Reference: #13S1213000

09 February 2016

**RE: 1 CARRINGTON STREET, SYDNEY**  
**TRANSPORT ASSESSMENT REVIEW FOR SECTION 96 APPLICATION**

Transport for NSW (TfNSW) has requested additional information regarding the Section 96 application lodged for the approved development at 1 Carrington Street, Sydney.

Car Park Ramping Swept Path Assessments

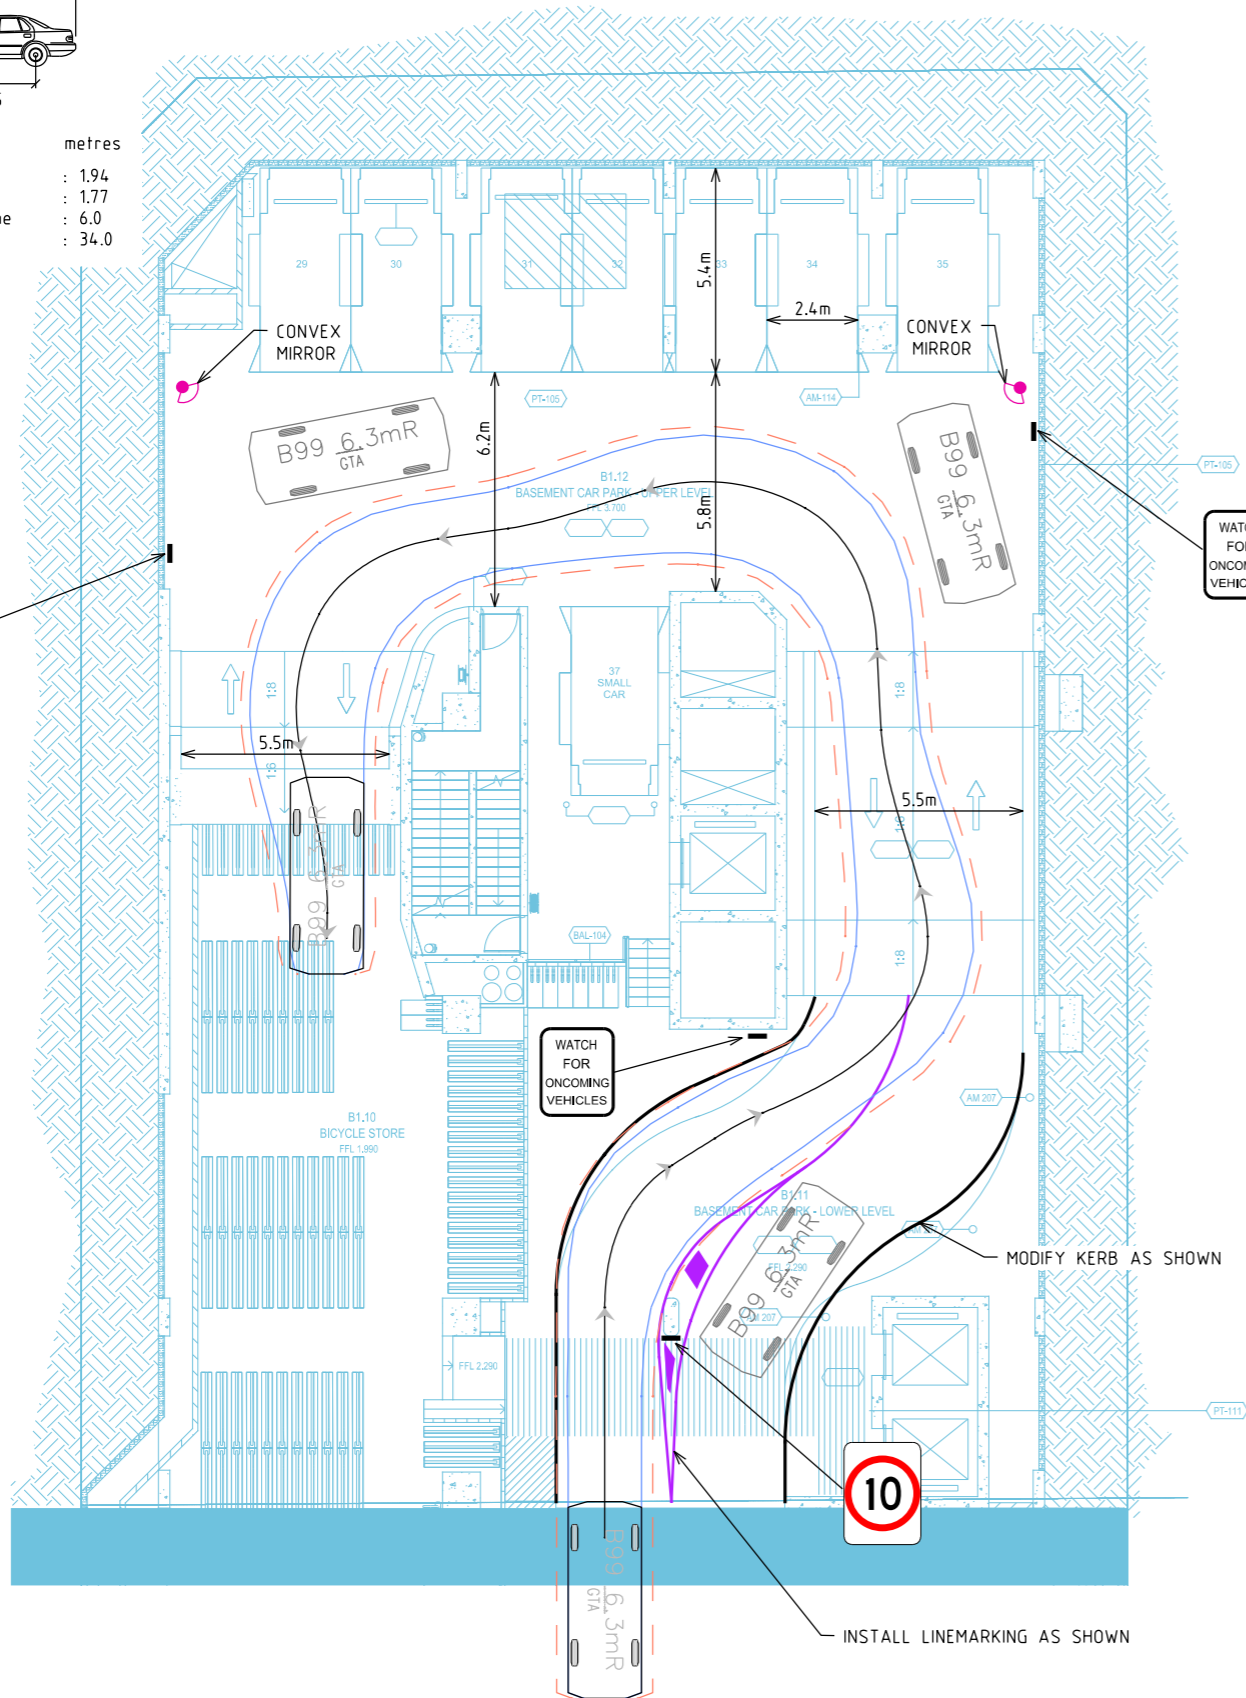
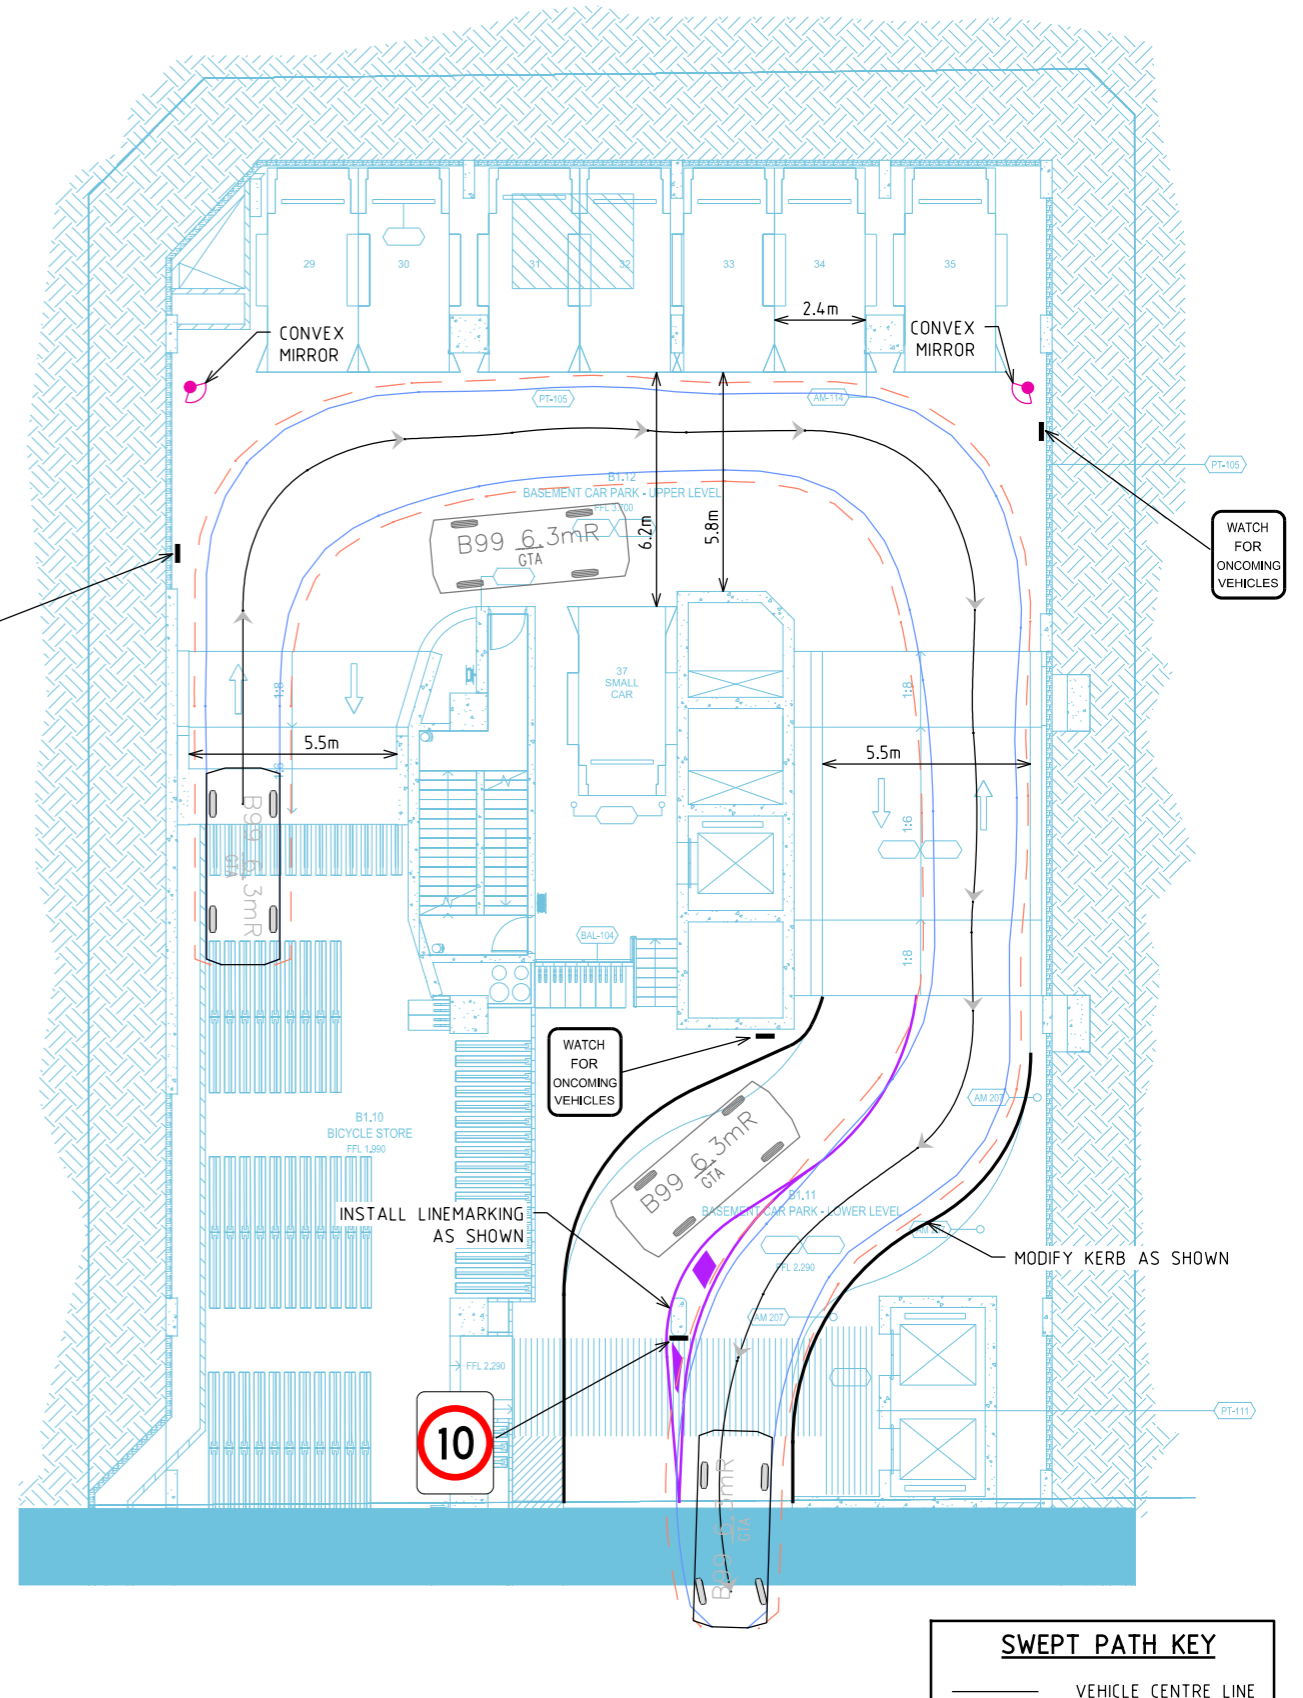
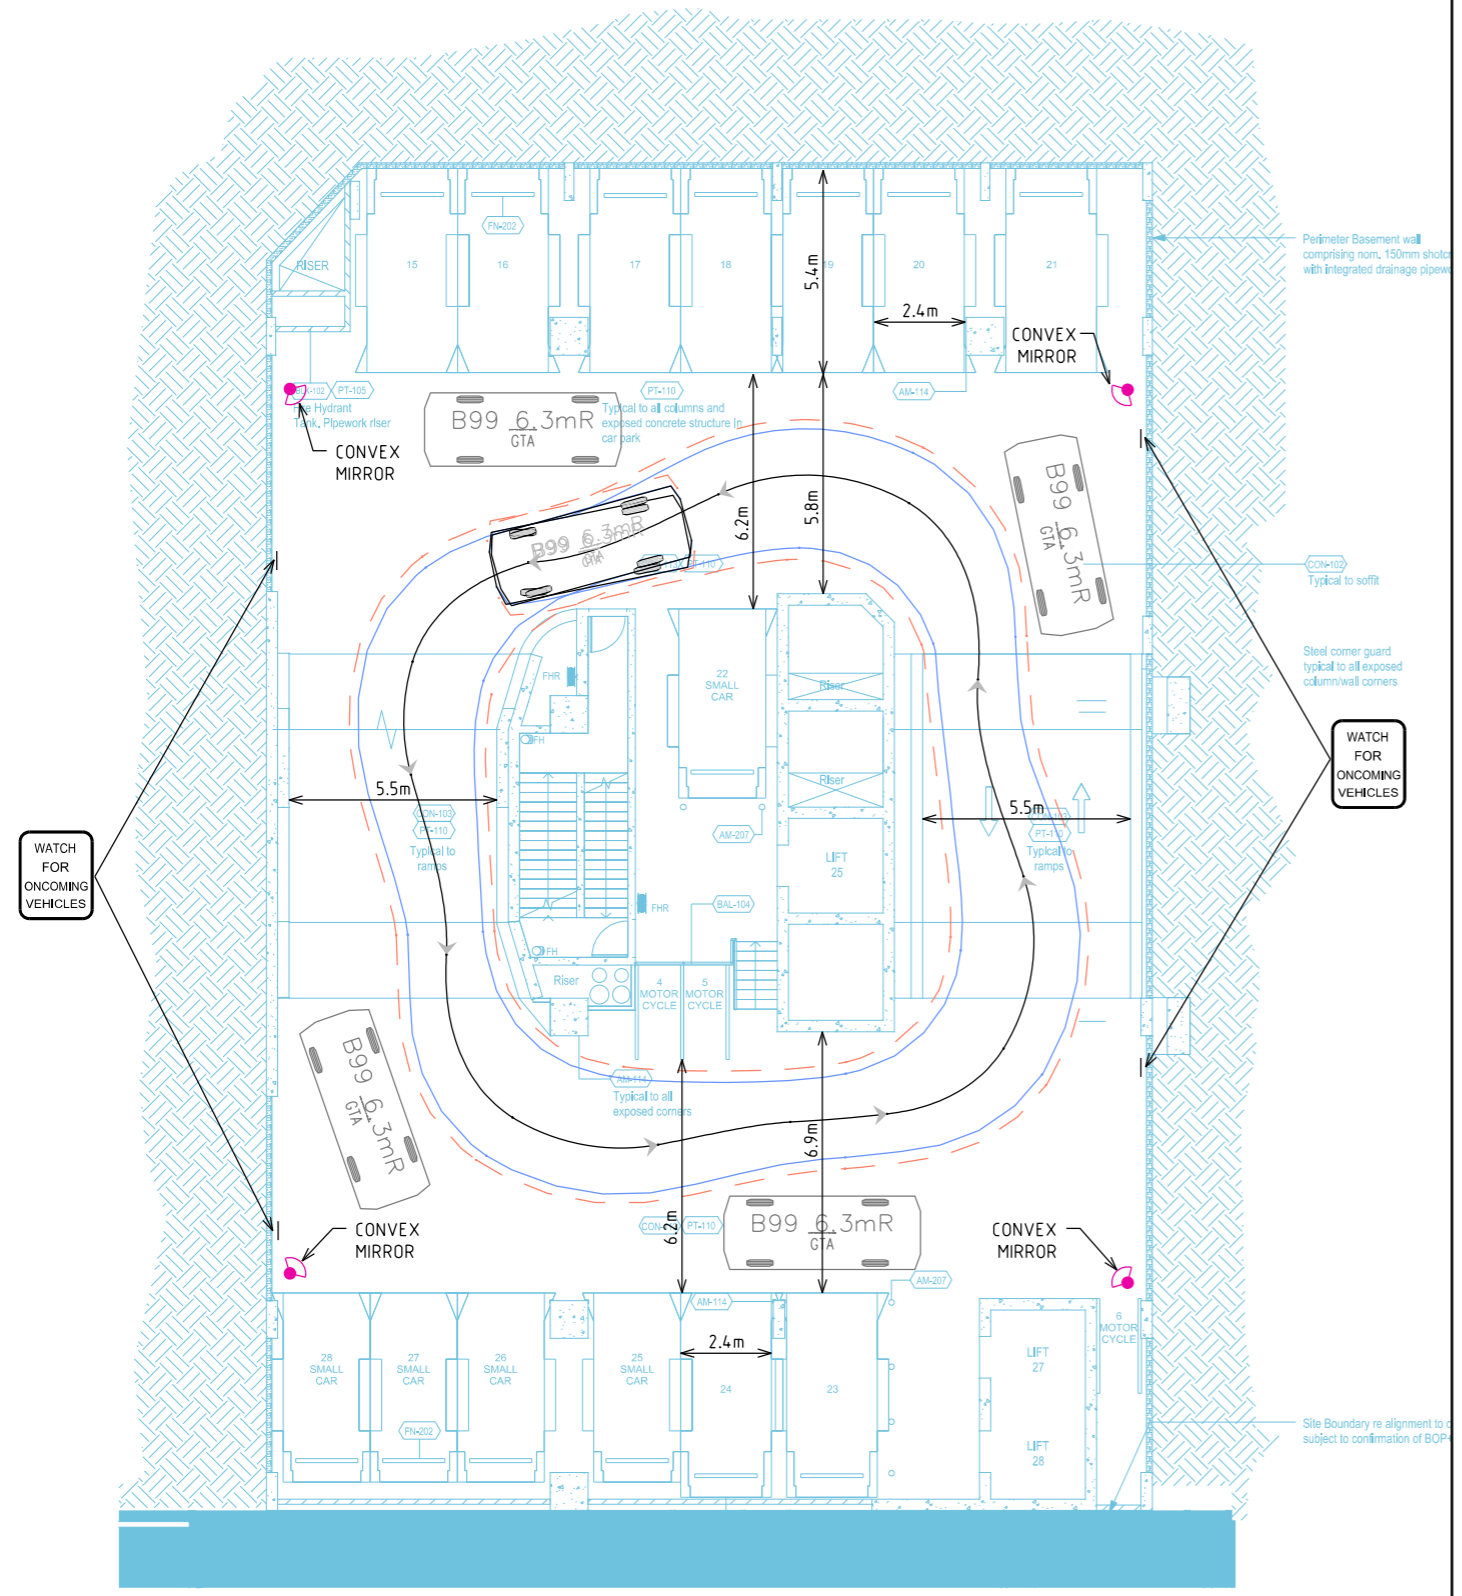
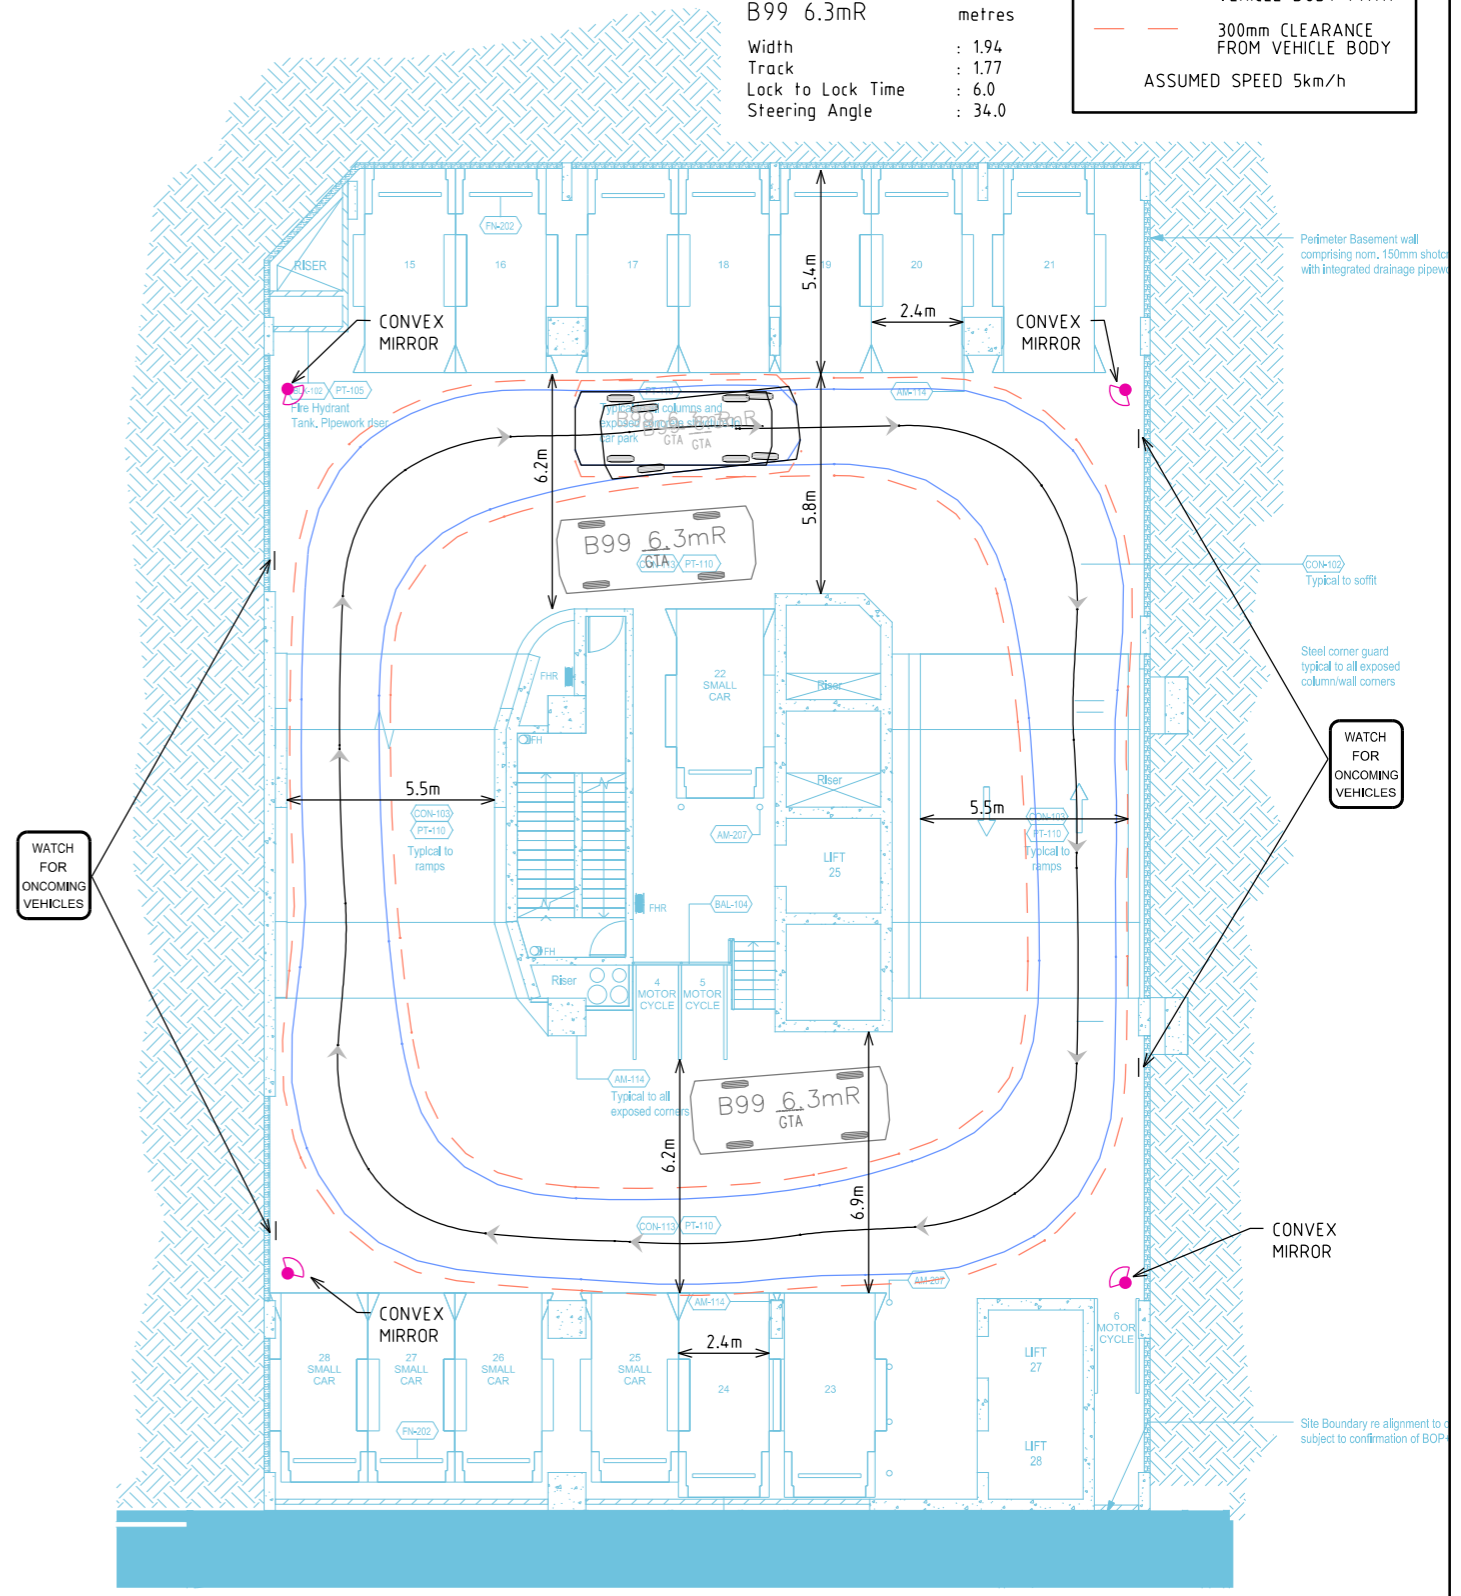
- "Access to Public Car Park
  - *The PDCP shows a narrow car park entry and a ramp to the public car park. It should be noted that the public car park access needs to include the vehicle entry lane as well as a pedestrian path. This would enable public to access the car park. It is not clear from the documentation prepared as part of the modification proposal whether the proposed public car park entry accommodates vehicle as well as pedestrian movements. TfNSW requests that the applicant demonstrates the width and gradient of the car park entry cater for vehicles as well as pedestrians in accordance with relevant standards."*

In addition, GTA also notes that public car park ramp, which is restricted to entry vehicle movements only, has been designed in accordance with AS/NZS890.1. Specifically, the ramp features a wall-to-wall width of 3.6m, including 0.3m clearances, compliant ramp grades which include a 1:16 transition at its top and a 1:8 maximum grade, and a height clearance of 2.5m.
